Phone: 0300 123 6780
Email: Kathryn.Walsh@lancashire.gov.uk
Your ref: 3/2025/0991
Our ref: 3/2025/0991/HDC/KW
Date: 12 February 2026

Location: Dilworth Cottage Ward Green Lane Longridge PR3 2ZL
Proposal: Demolition of existing dwelling and erection of new detached self-build dwelling including external landscaping
Grid Ref: 362793 437734

Block Plan Scale 1:500

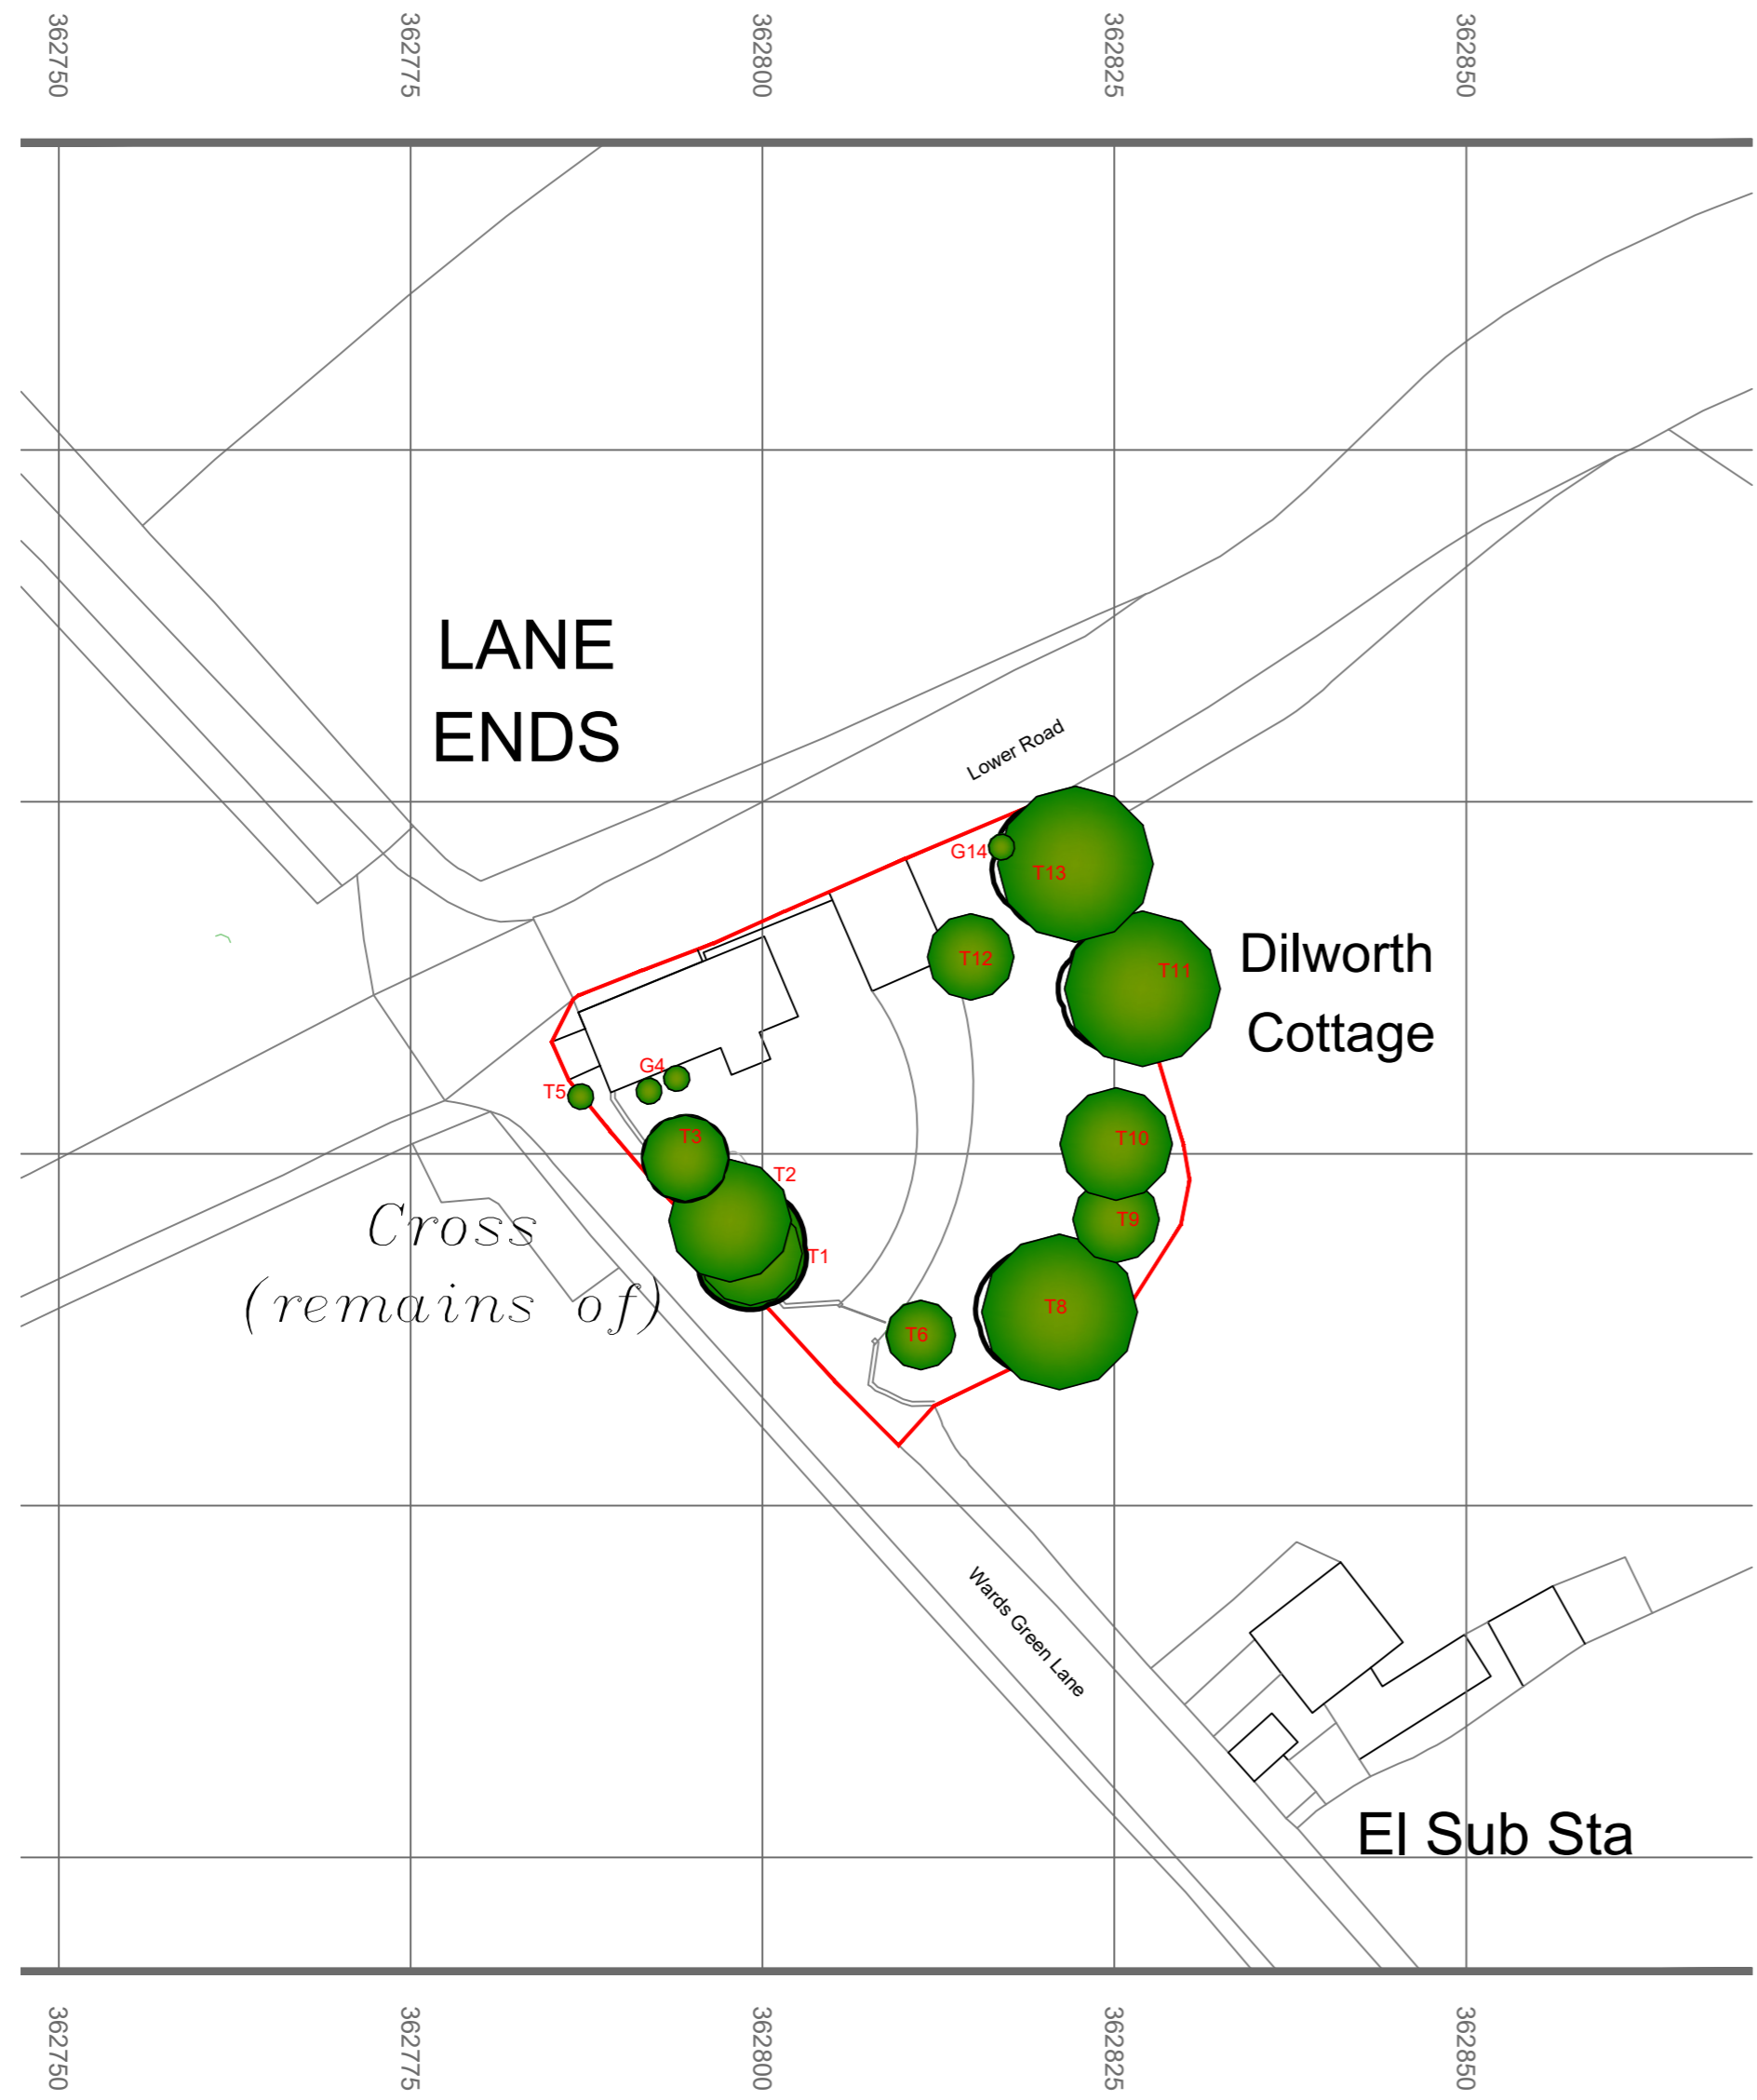
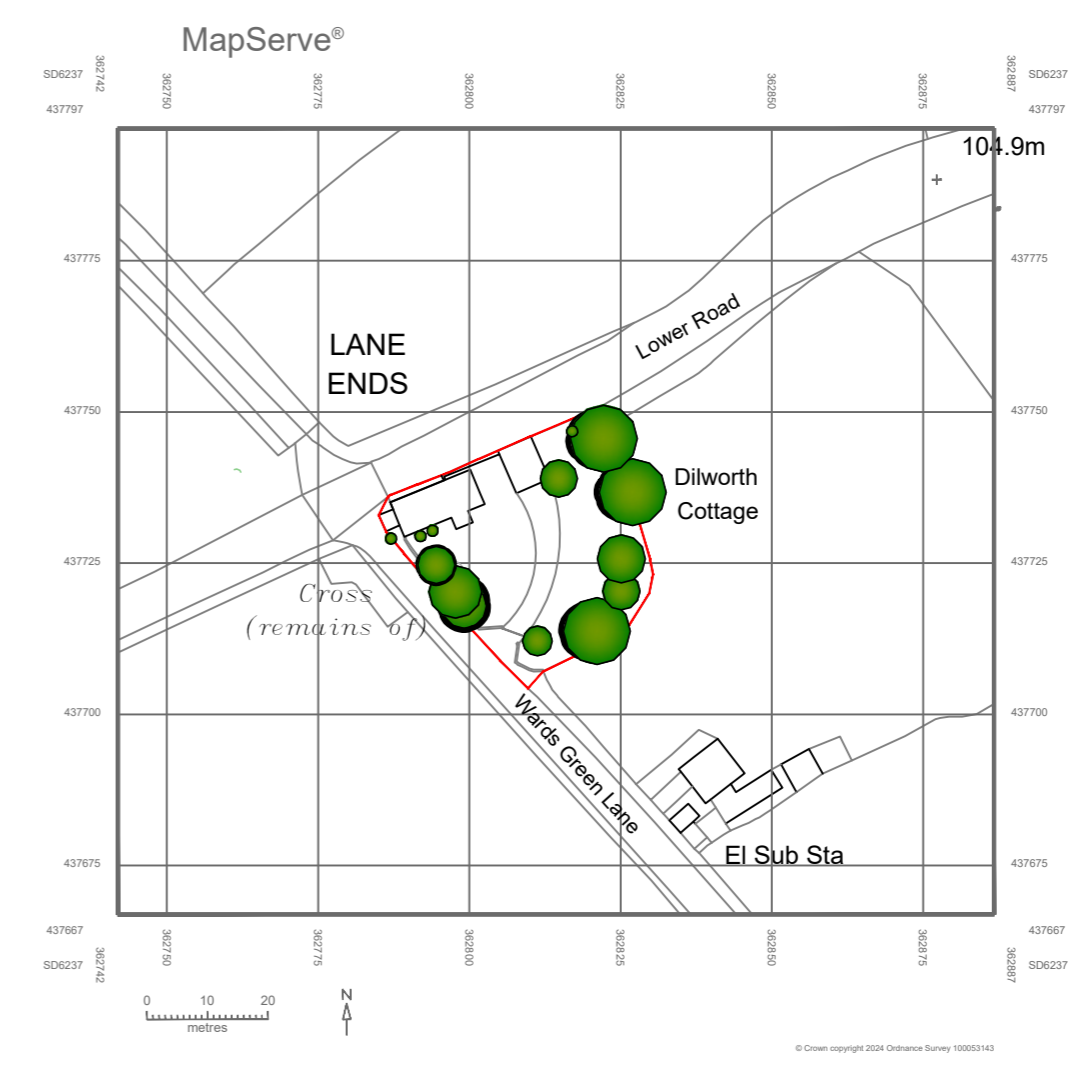
The proposal will utilise an existing access from Ward Green Lane, which is an unclassified road subject to a 60mph speed limit. Currently, there is a gate approximately 3.7m from the carriageway edge. While this arrangement is existing, it does not meet current standards and as such, the gate shall be removed or must be set back 5m into the site, which will allow vehicles to pull clear off the carriageway before operating the gate, reducing conflict within the highway.

The existing dwelling currently sits adjacent to Lower Road and Wards Green Lane junction. The proposal will result in the new dwelling being positioned further away from the edge of the carriageway, creating a better line of sight for vehicles at the junction of Lower Road. The retaining boundary wall adjacent to Lower Road will be lowered to 0.9m which will assist in visibility at the junction allowing drivers to see over the wall and observe oncoming traffic.

Amendments to the retaining wall fronting Lower Road will require the applicant to provide a structural report setting out how any structures will be assessed, excavated, constructed, strengthened or demolished, which will be conditioned as part of any approval.

The LHA has reviewed drawing number 1403 - L01(006), revision B, titled Landscape Plan and are aware that the dwelling complies with the LHAs parking standards as defined in the Joint Lancashire Structure Plan. There is also room to turn within the site and leave in a forward gear.

Whilst there is an existing double garage it does not meet the recommended minimal internal dimensions for a double garage which is 6m in length and 6m wide. Where double garages are smaller than the recommended minimum internal dimension of 6 x 6m they should not be counted as a parking space.

3. No development shall take place, including any works of demolition or site clearance, until any gateposts erected at the access are removed or positioned 5m behind the nearside edge of the highway. Any gates erected shall open away from the highway and shall remain positioned 5m behind the carriageway edge thereafter.

5. No part of the development hereby approved shall commence until a scheme for the retaining structure adjacent to the highway has been submitted to, and approved by, the Local Planning Authority in consultation with the Highway Authority.
